Ribble Valley Borough Council  
Development Control

Application no: 3/2019/0500

Address: Thorn Street Garage, Clitheroe  
Proposal: Demolition of Redundant buildings and remodelling of internal area

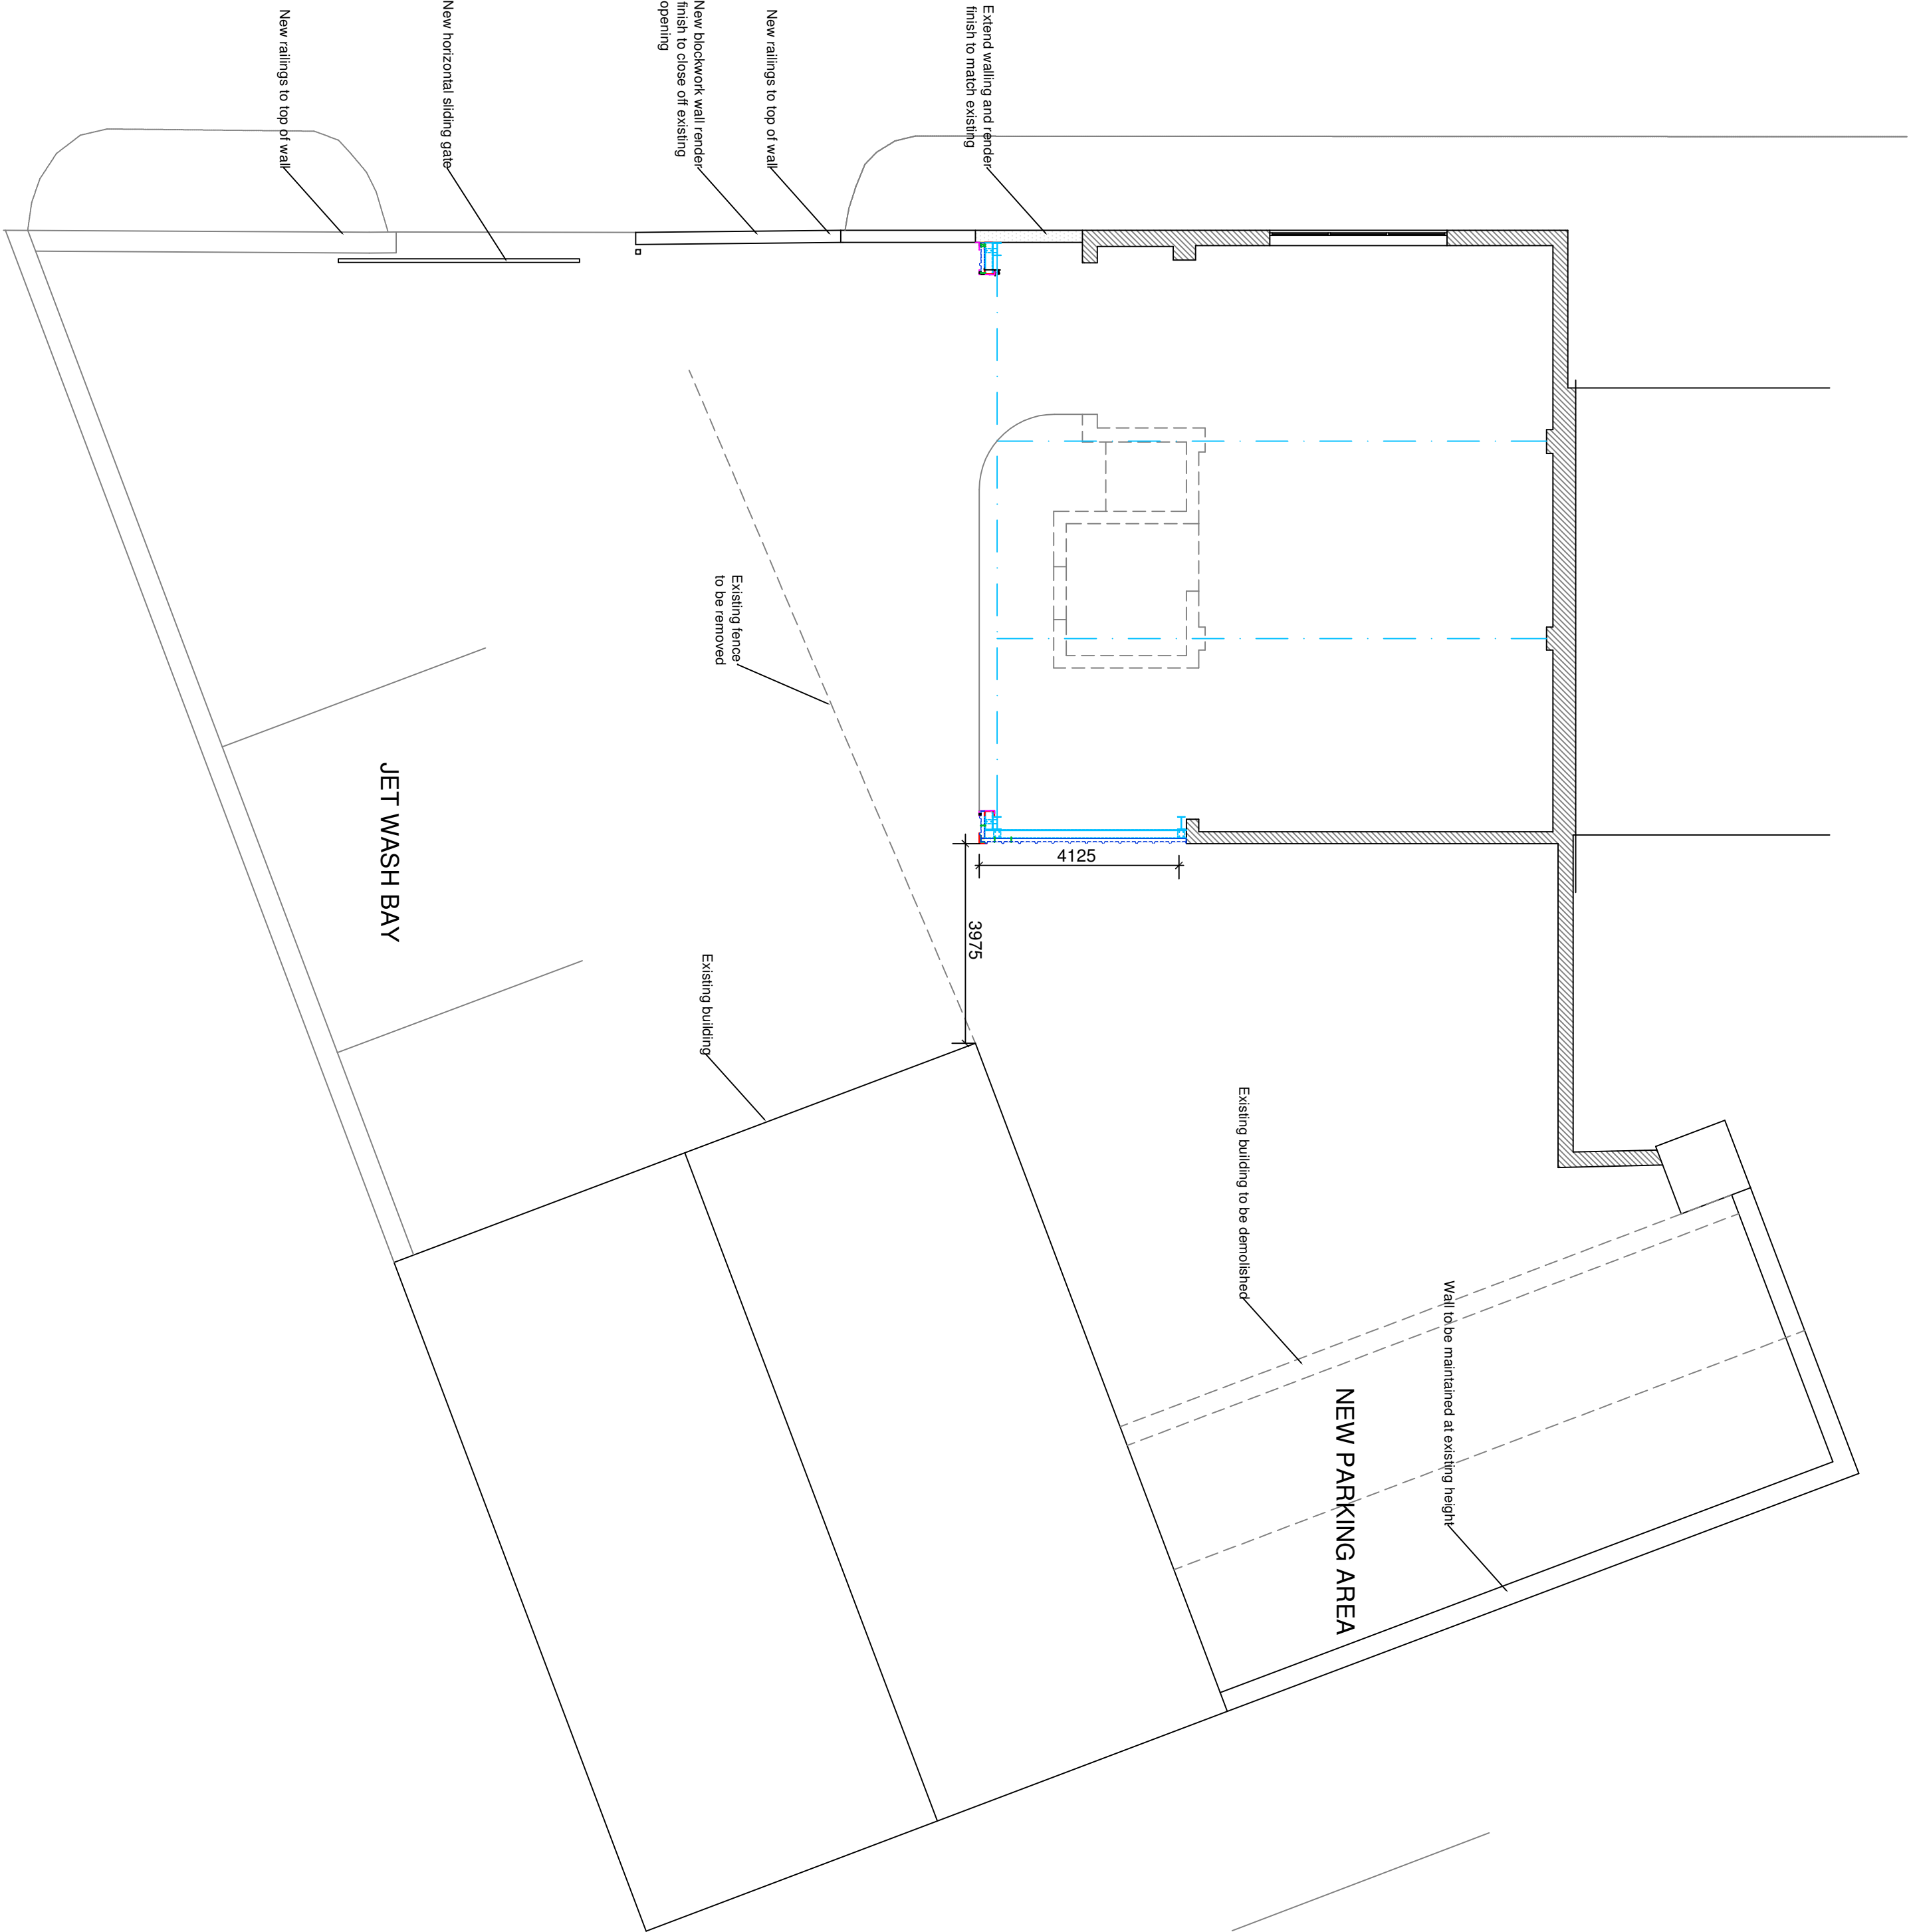
1 The development proposes to create a single access point into the site. Currently there is a kerbed radii delineating the access point. There is a likelihood that without the kerbing extending to the revised access point there may be a temptation to parki across the redundant access point and cause an obstruction to the footway. In order to avoid this the existing kerbing would need to be extended and the footway reinstated.

2 The existing "H-bar" marking will need to be amended to reflect the new access arrangement.

3 The layout indicates a jet wash located within the yard area. I would need confirmation that its use is not available to the general public.

1. The existing access shall be physically and permanently closed and the existing verge/footway and kerbing of the vehicular crossing shall be reinstated in accordance with the Lancashire County Council Specification for Construction of Estate Roads concurrent with the formation of the new access. Reason: To maintain the proper construction of the highway.
2. No part of the development hereby approved shall commence until a scheme for the construction of the site access has been submitted to, and approved by, the Local Planning Authority in consultation with the Highway Authority. Reason: In order to satisfy the Local Planning Authority and Highway Authority that the final details of the amended access proposals are acceptable before work commences on site.
